605 Stevens Ave., BP# 2016-00470 plan review comments

Please replace the attached revised drawings into your files for the Motherhouse Senior Housing, 605 Stevens Ave, BP#2016-00470

A3.11

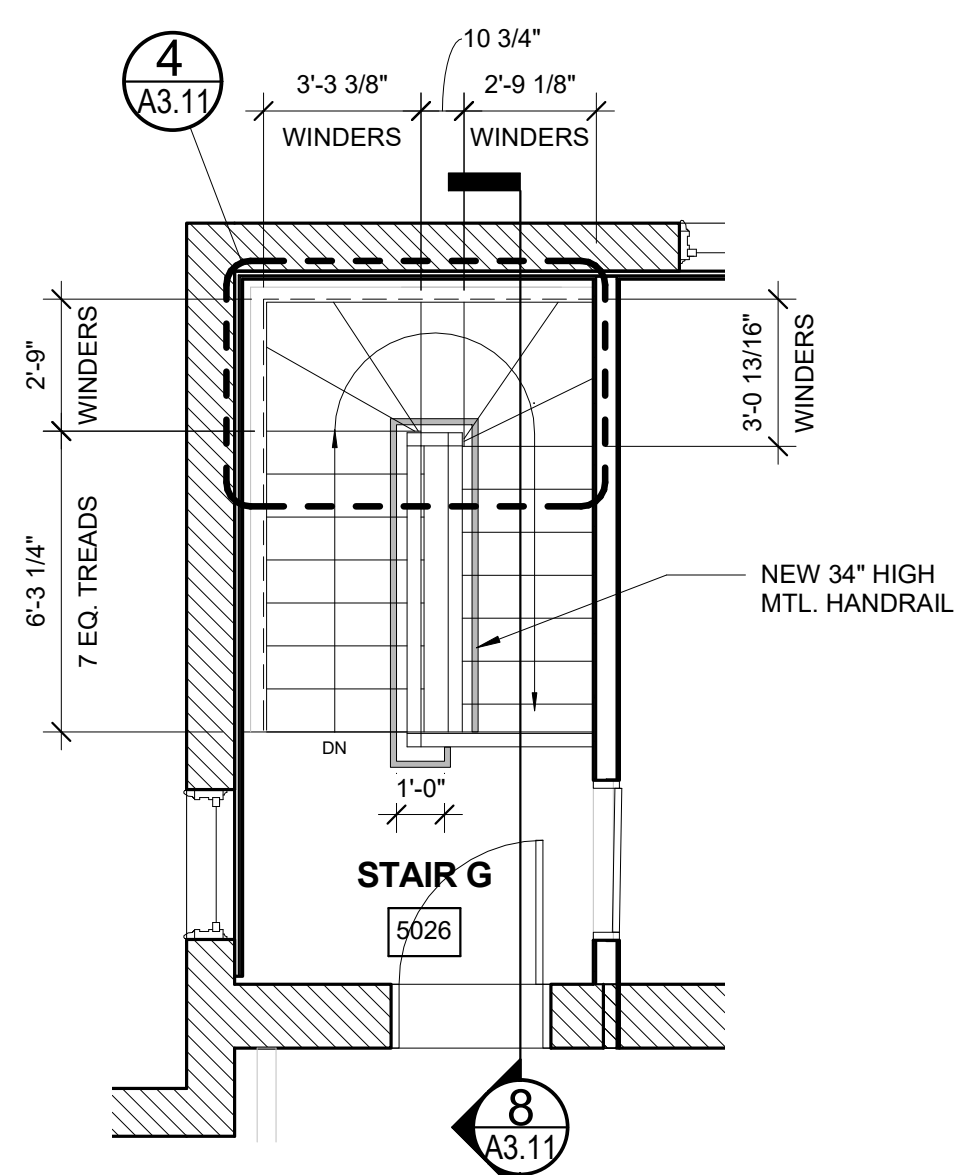
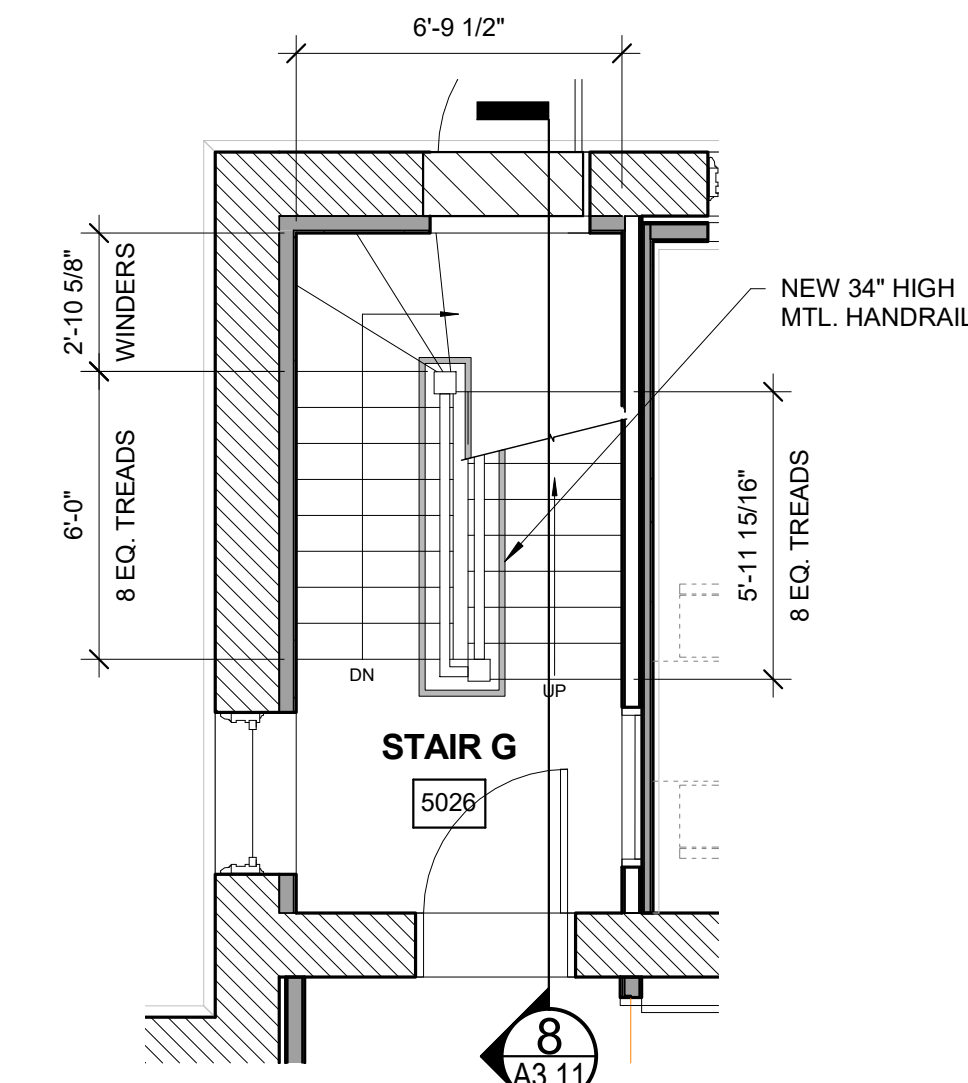
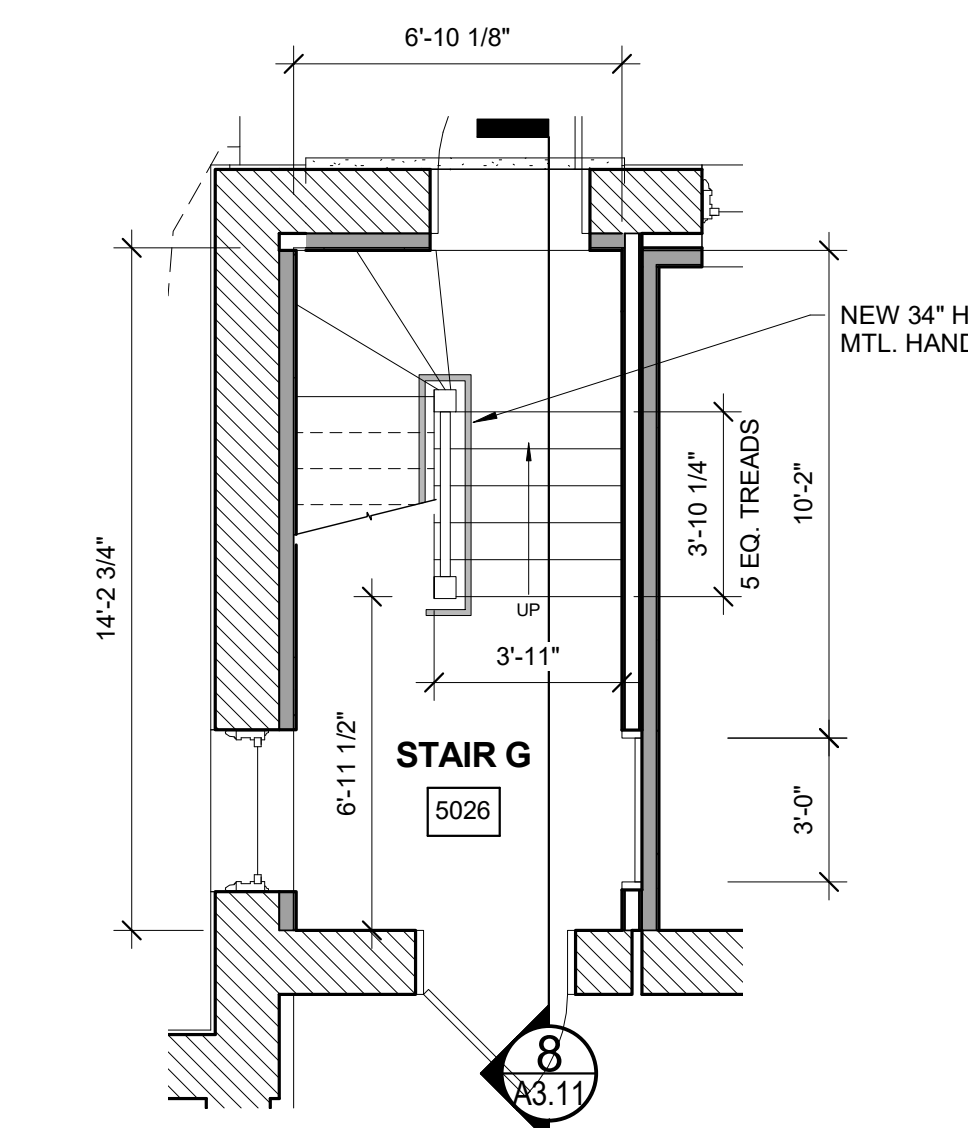
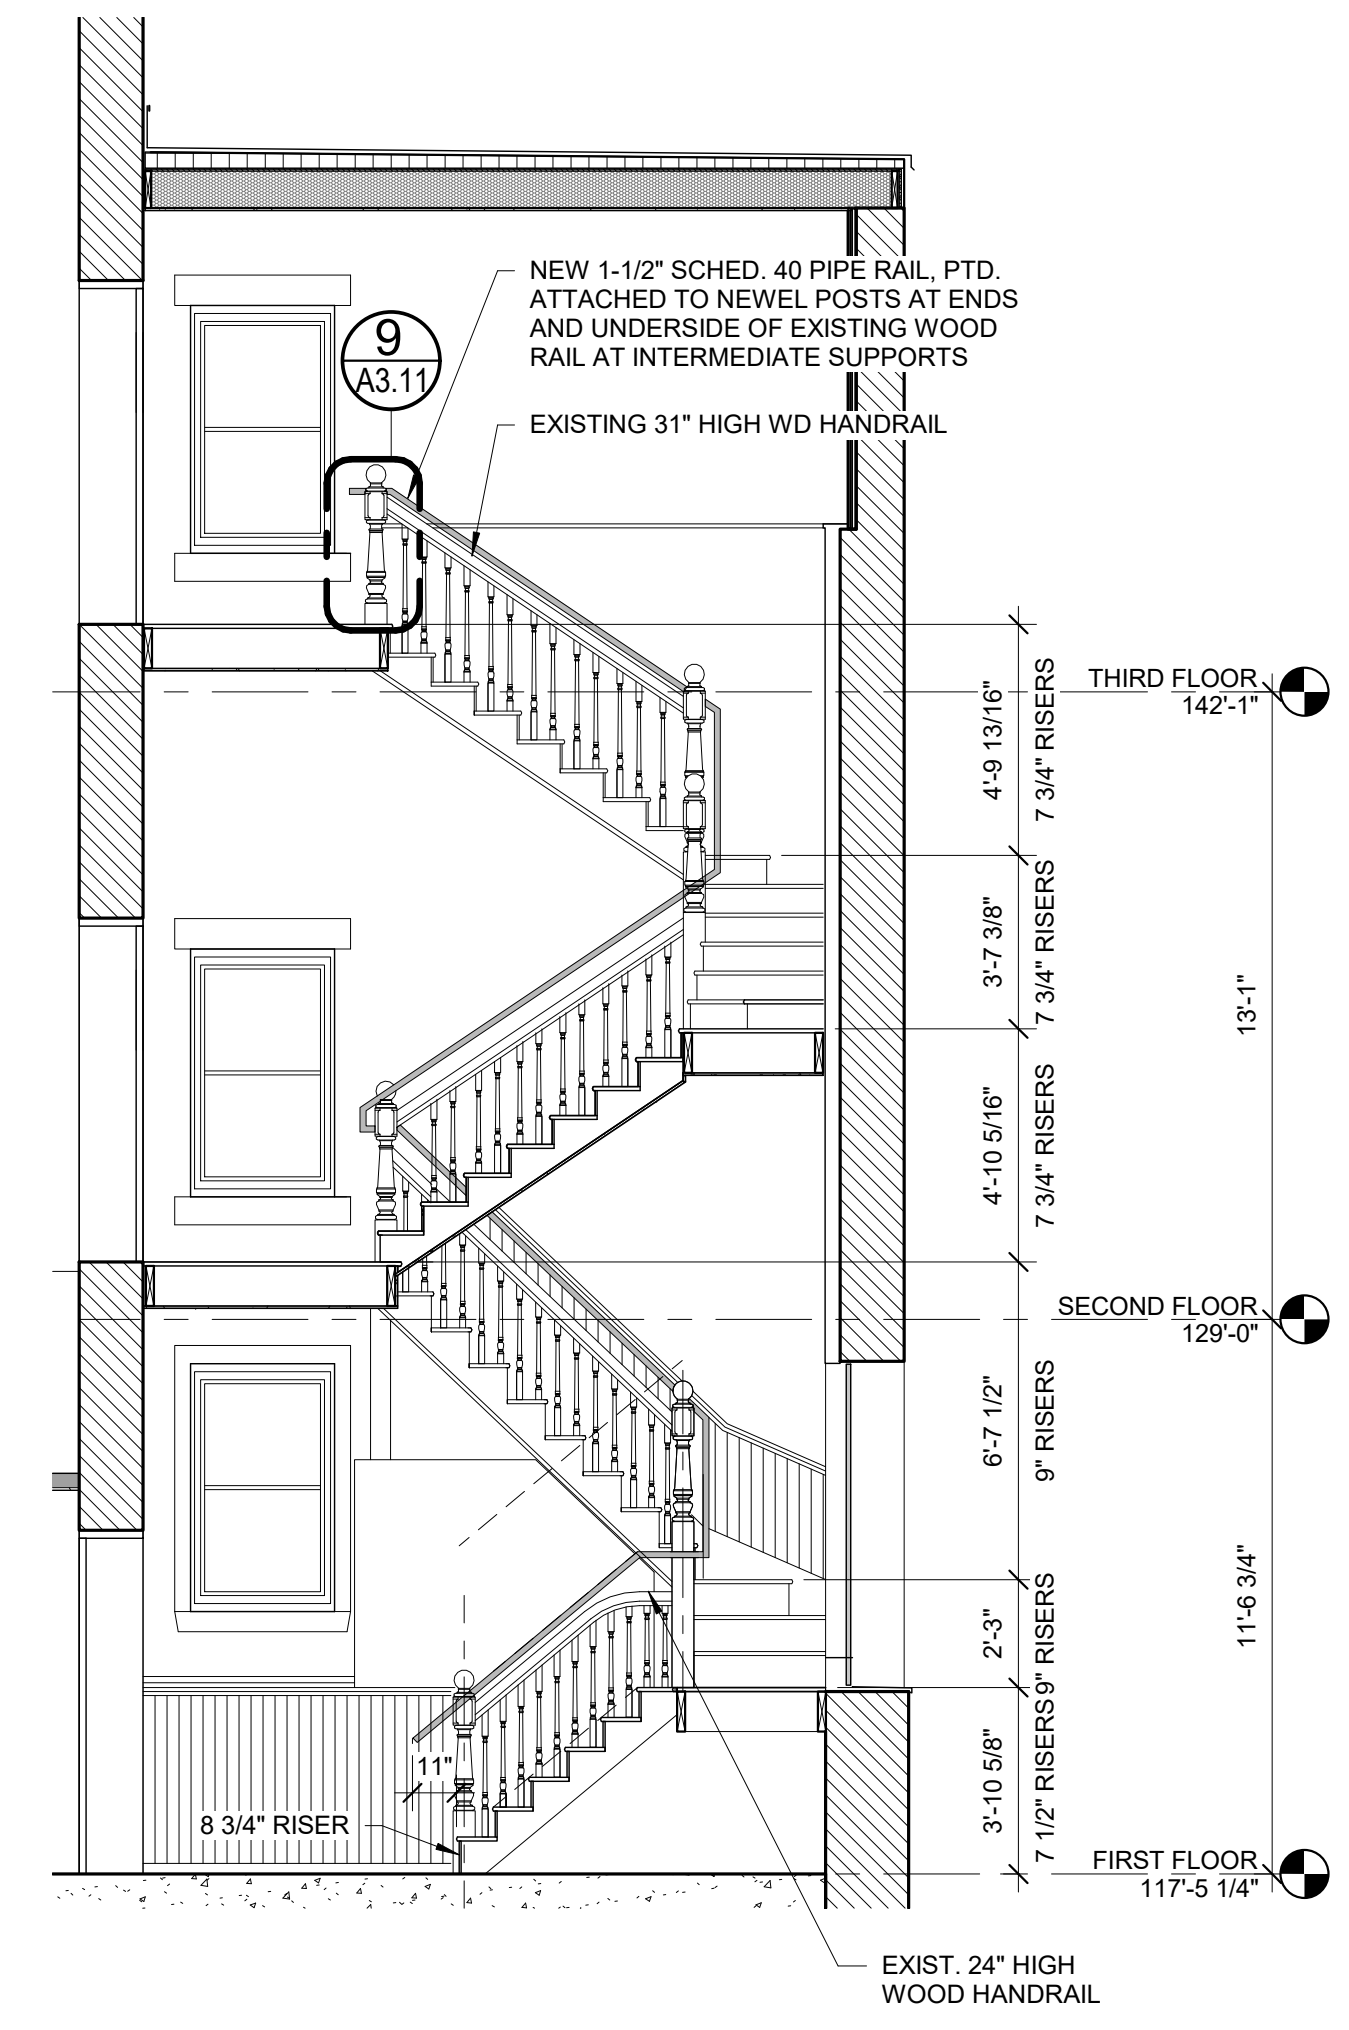
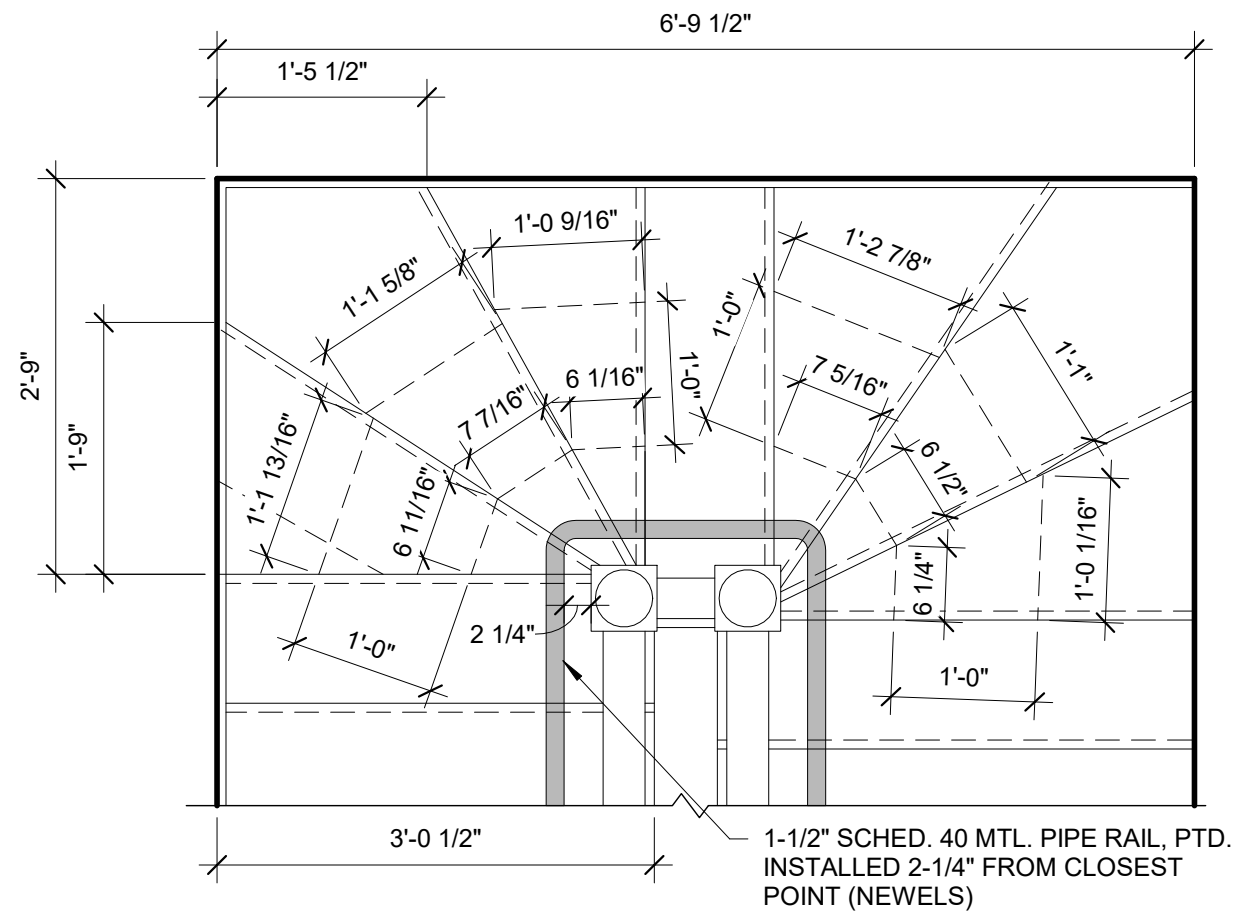
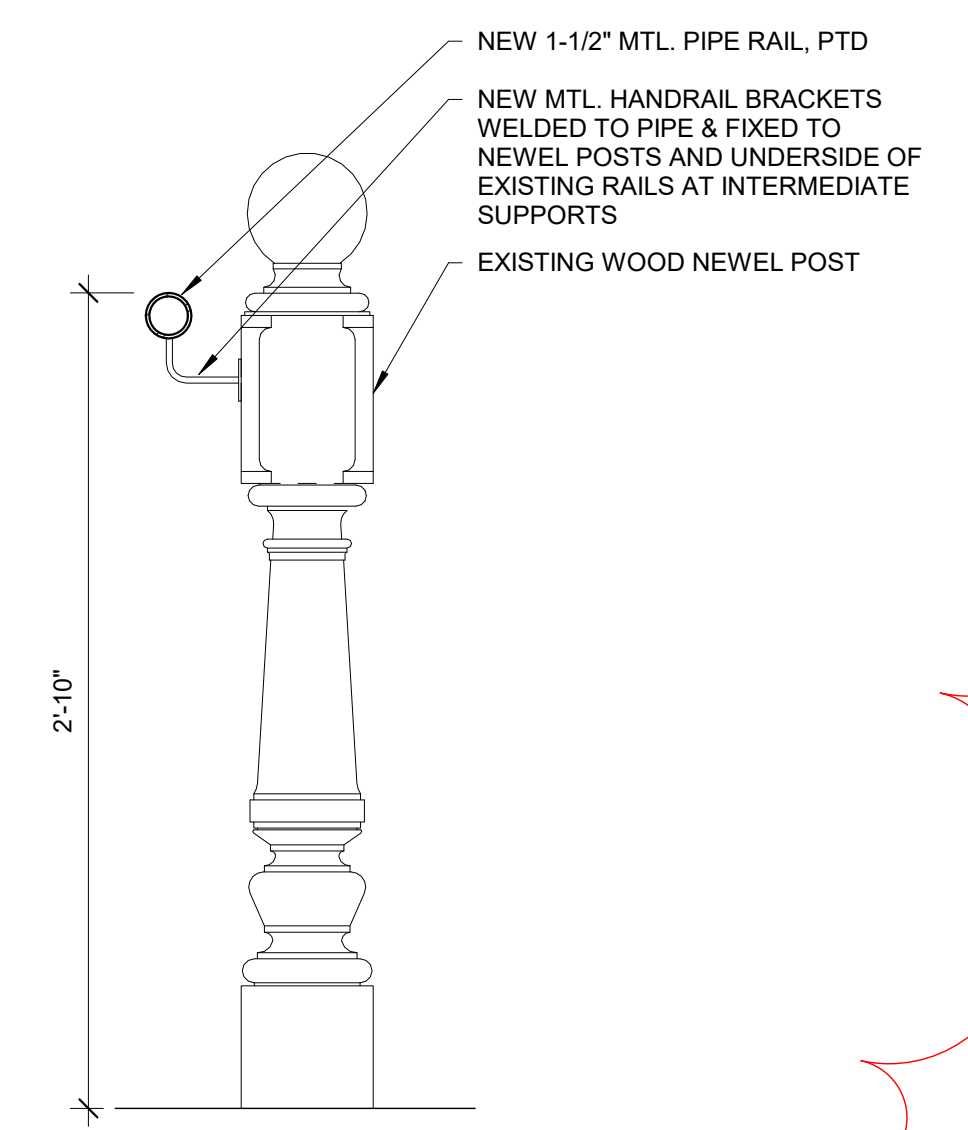
Attached is a drawing of our Stair G that we discussed with you in your office. We are asking for a waiver from you on the existing conditions with a few upgrades that we feel adequately improve the life-safety of this stair enough to make is useable.

Your comment on Stair G has been responded to in the email below. The drawing has been clouded since the one sent yesterday to highlight the changes. The other attached drawings are also clouded where revised.

Regarding your request to revise the code summary to include information on the 2nd means of egress from the assembly space, we have revised drawing CS.00. We have not noted on this sheet, as it did not form part of the standard code review, that we have increased the life safety features of Stair G by adding new handrails where the existing was too low. This will also keep people a little further away from the narrowest sections of the existing winders.
